Advice to the local planning authority

To LPA	Welwyn Hatfield
LPA planning ref no	6/2022/1355/MAJ
Our ref	Pgo-3508
Site address	Former Beales Hotel Comet Way Hatfield AL10 9NG
Proposal description	Demolition of existing building and construction of 142 residential units (Use Class C3) with private and communal amenity space, landscaping, access, associated car and cycle parking, refuse and recycling storage and supporting infrastructure.
Date on fire statement	24/05/2022
Date consultation received	28/06/2023
Date response sent	03/07/2023

drawing: General Arrangement
 Proposed Seventh Floor Plan

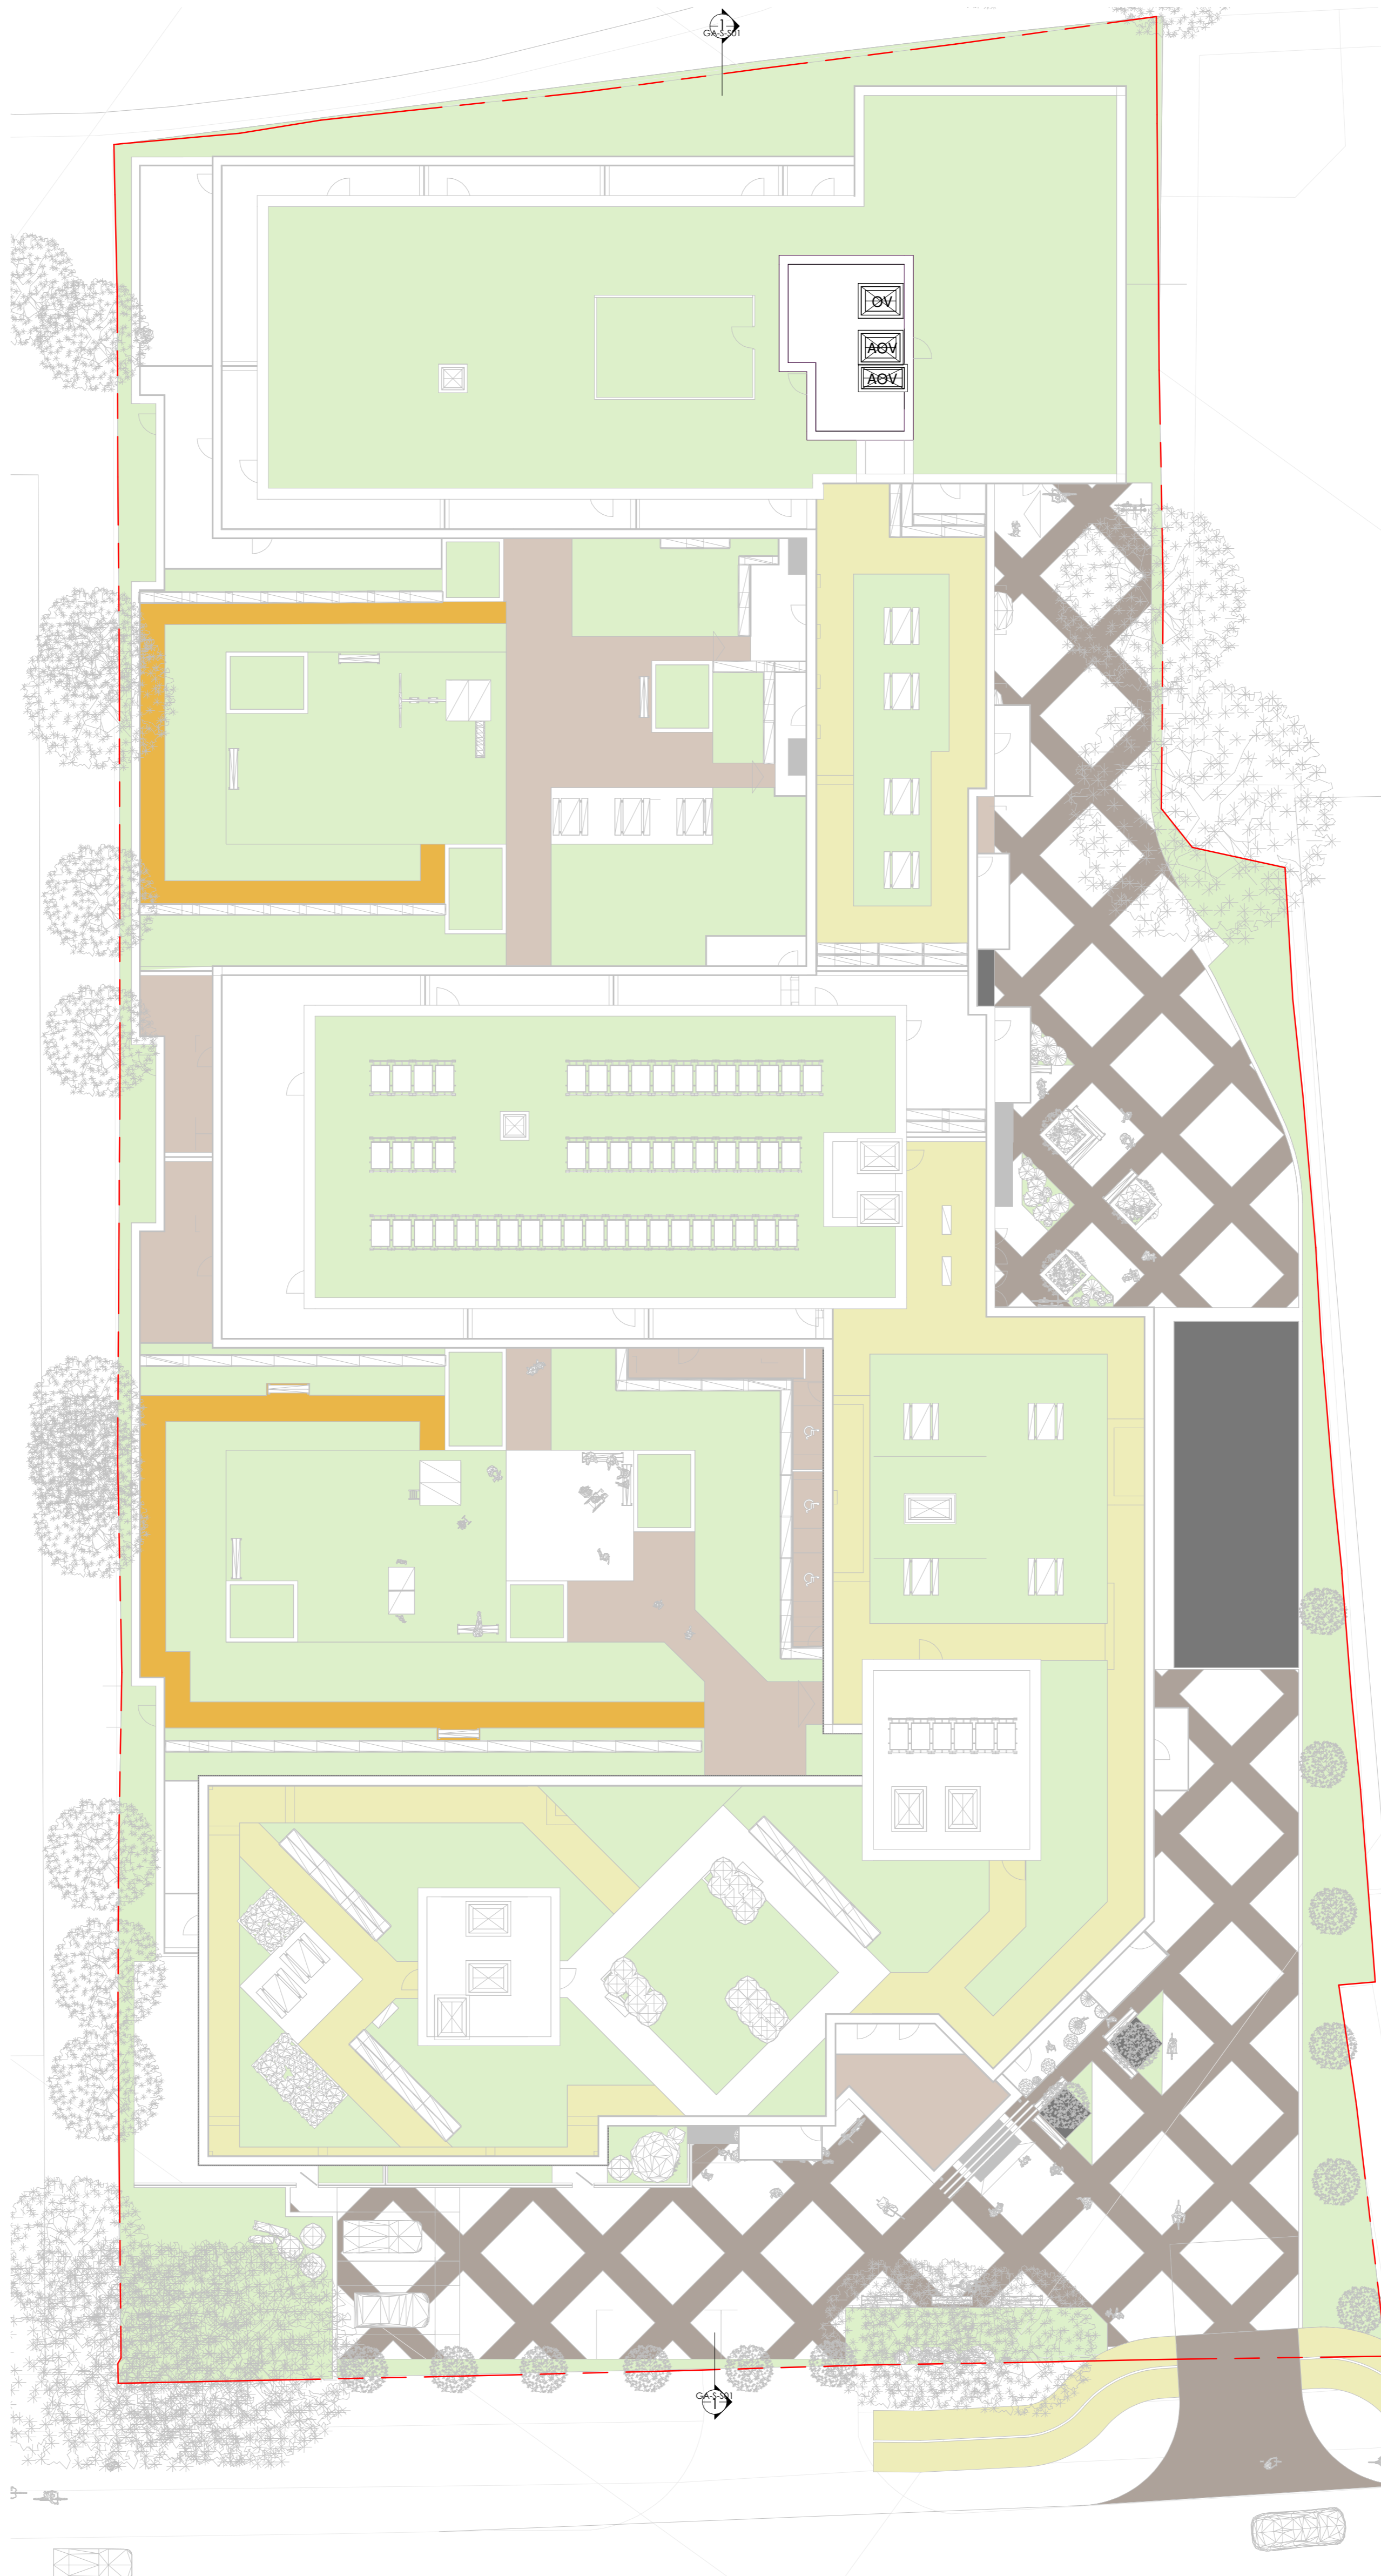
"I can confirm that regarding the proposed 7th floor plan, it does not have a roof terrace and, therefore, will not be used as an amenity area. Appreciate the plan doesn't help with the various colours but the only 7th floor element is the plant area which has no doors or openings to the roof. See below circled. The doors/parts in the lighter shade denote the lower floors.

- 1.9 The LPA response clarifies the uncertainty regarding the use of the seventh floor in this application and confirms it is not to be used as a roof top terrace amenity space.
- 1.10 Following a review of the further information received from the LPA, HSE is satisfied with the fire safety design to the extent that it affects land use planning.
